**Consultation Response from KC,
Highways Development Management**

2023/92072 164, Lockwood Road, Lockwood, Huddersfield, HD1 3QR

Conversion of basement to form self contained apartment and refurbishment of existing dwelling with associated internal and external alterations

Date Responded: 21-8-2023.

Cellar - P
1 : 50

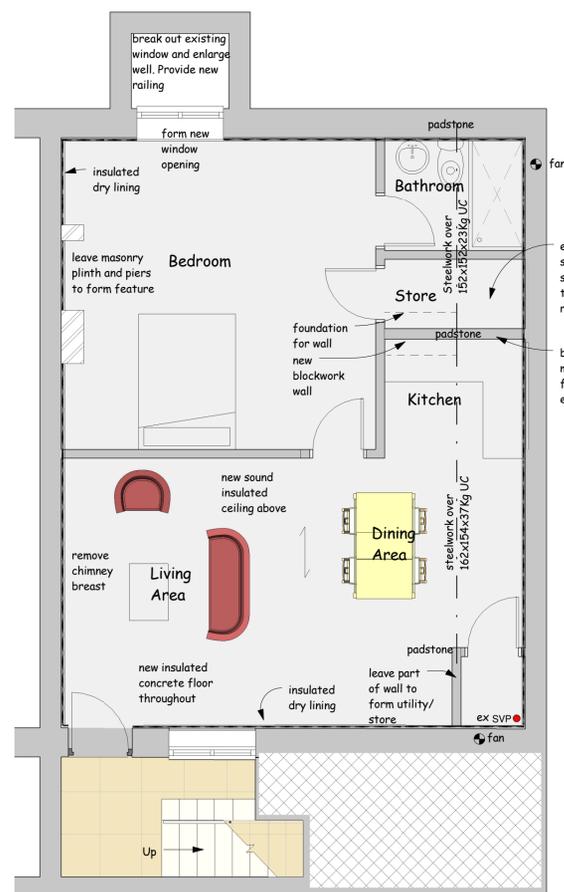
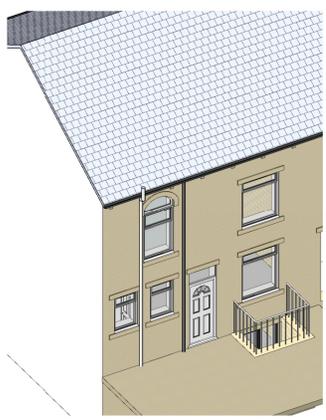
The basement is to become a self-contained apartment. A new and enlarged 'basement well' with new steps and a gated entrance provides a new access to the proposed apartment.

The Highways Structures section have requested that a condition is attached to any permission requiring details of the design and construction of the new basement wall to facilitate the creation of a new access from Lockwood Road.

Before the development commences, the proposed design and construction details for the new basement wall to facilitate the creation of a new access to the basement floor, adjacent to A616 Lockwood Road shall be submitted (via the submission of an AIP) and approved by the Highway Authority in writing. The approved scheme shall be implemented prior to the commencement of the proposed development and thereafter retained during the life of the development.

Reason: To ensure that any new retaining structures do not compromise the stability of the highway
